Response to Planning Application

From: Arun District Council Leisure & Greenspace

Application ref: FP/274/21/OUT Revised Consultation

Location: Bognor Regis Golf Club Downview Road Felpham PO22 8JD

Urban
Hallam Land Management
Bognor Regis
Existing Golf Club
drawing title
Tree Retention Plan

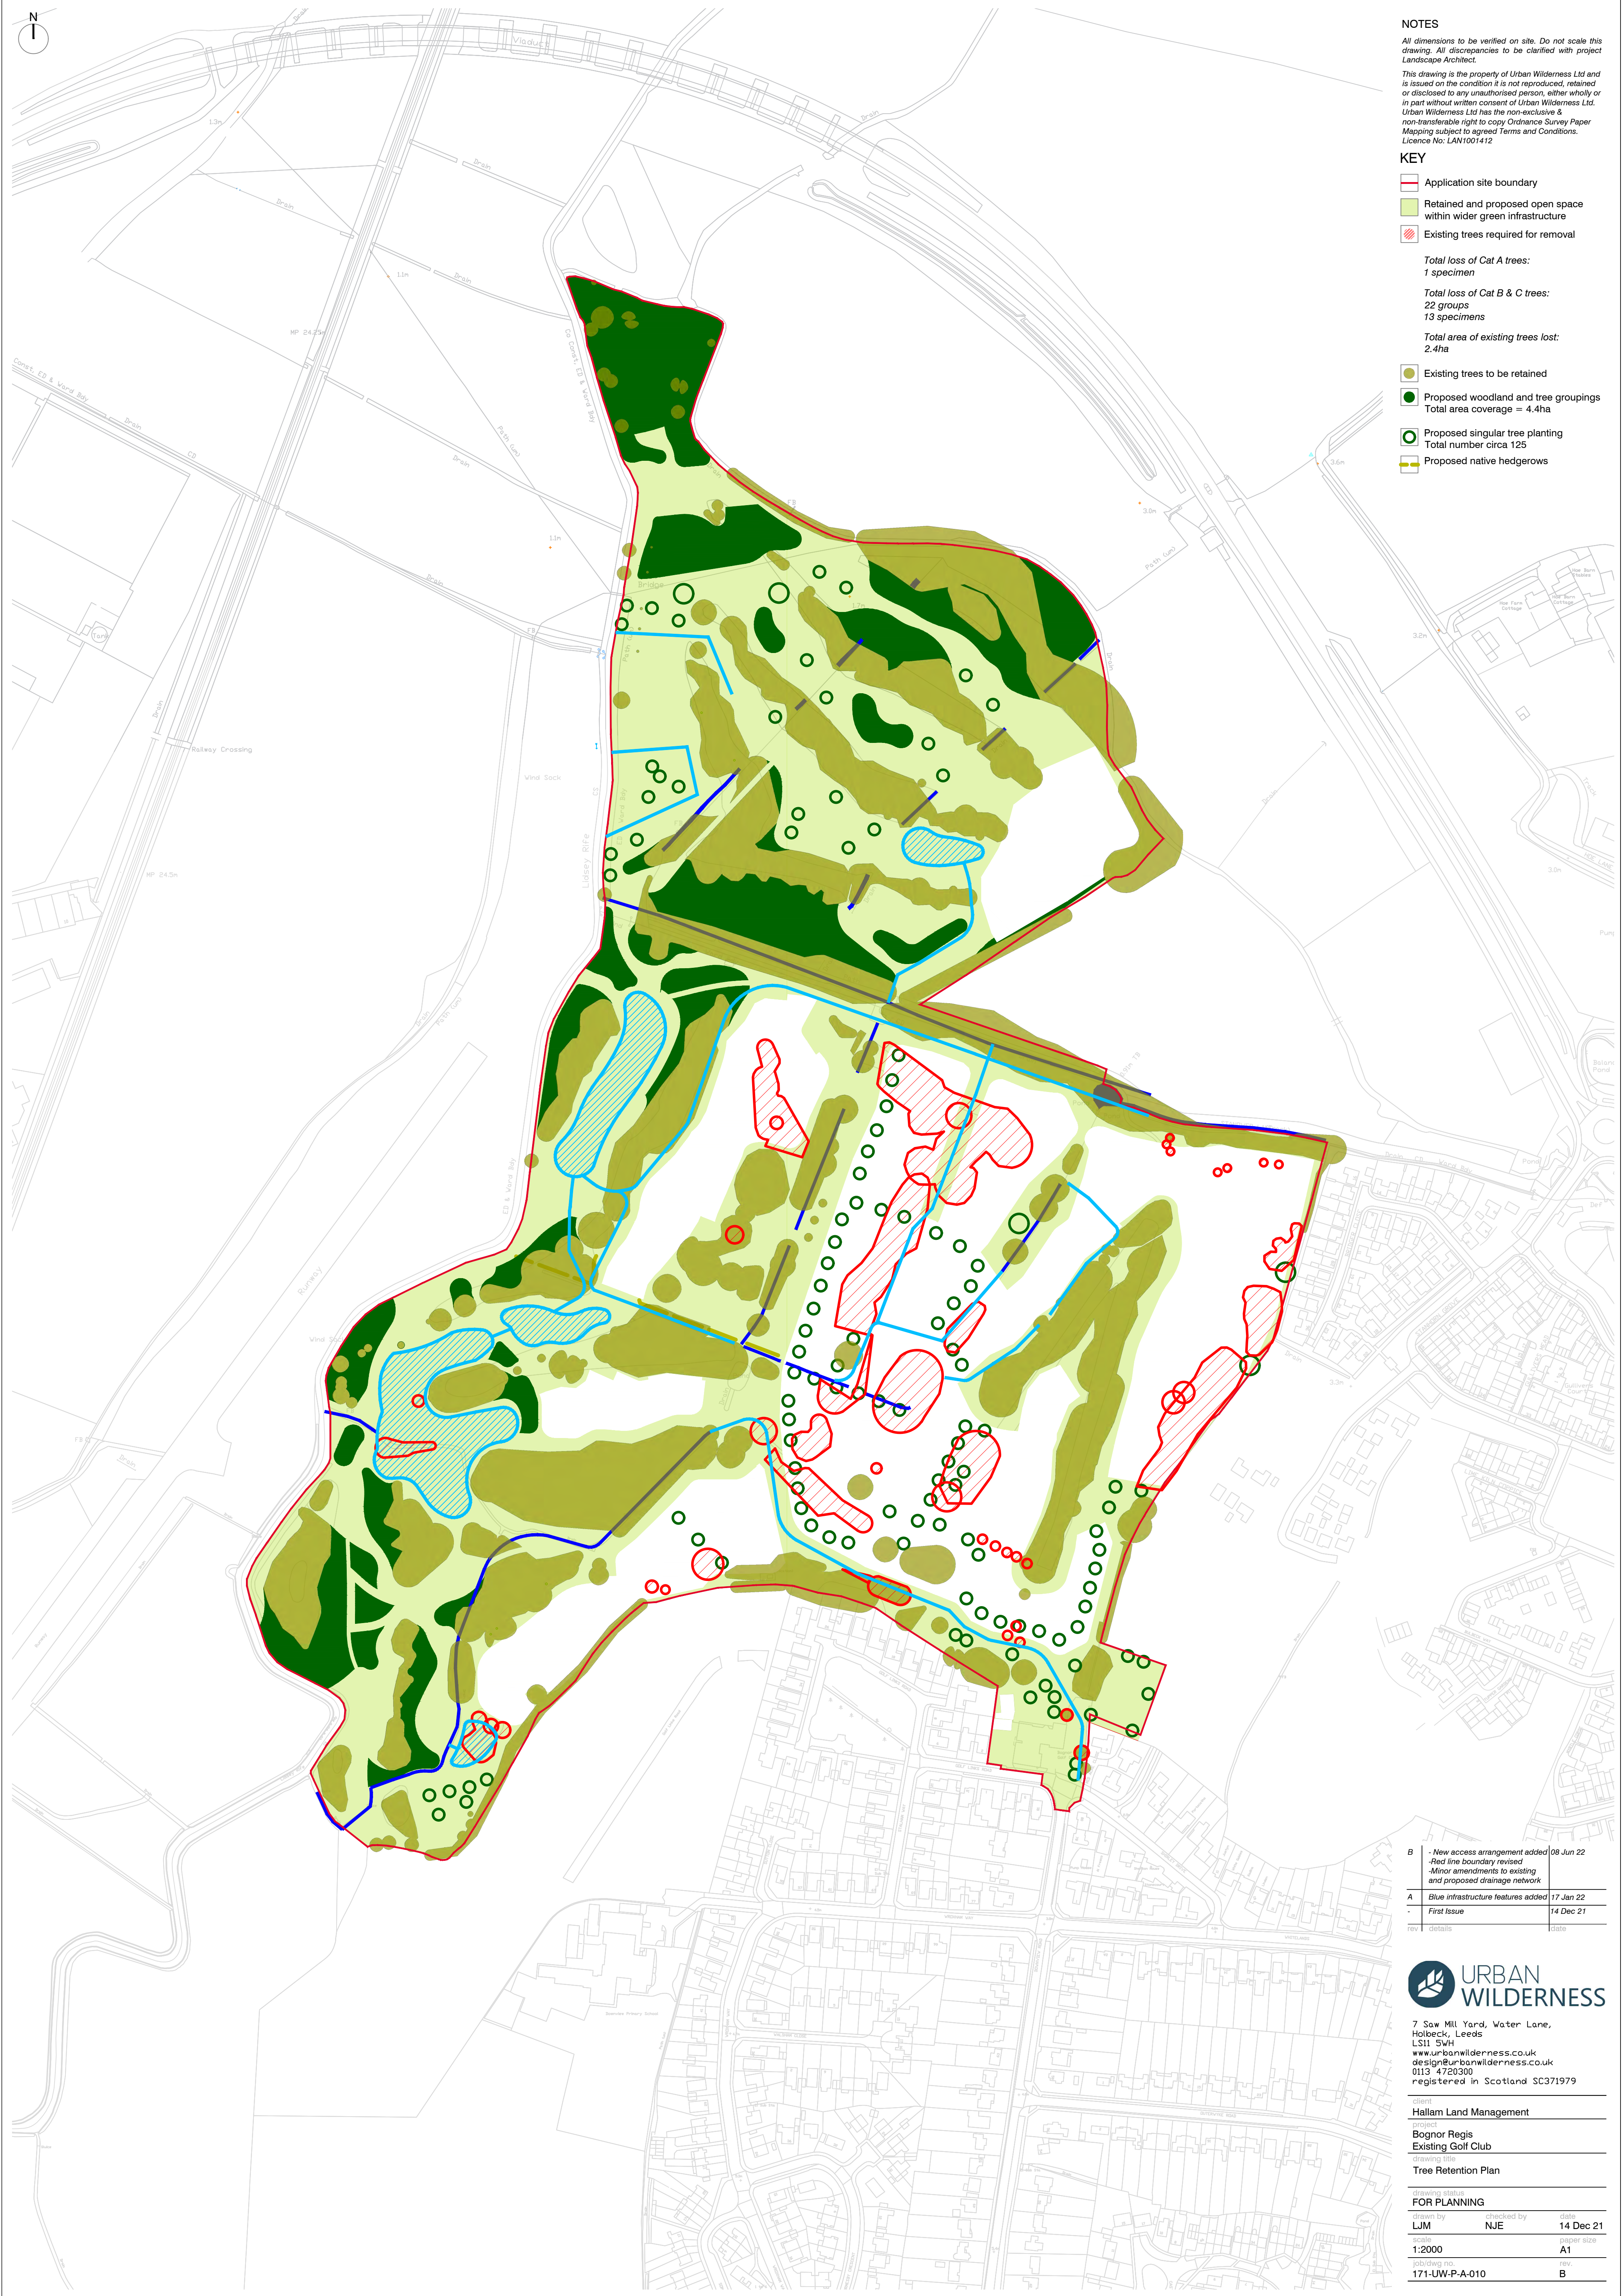
Tree Retention Plan – 171-UW-P-A-010 Rev A will need to be consultation with the LPA Tree Officer as existing trees and hedges have significant and considerable value to this development proposal.
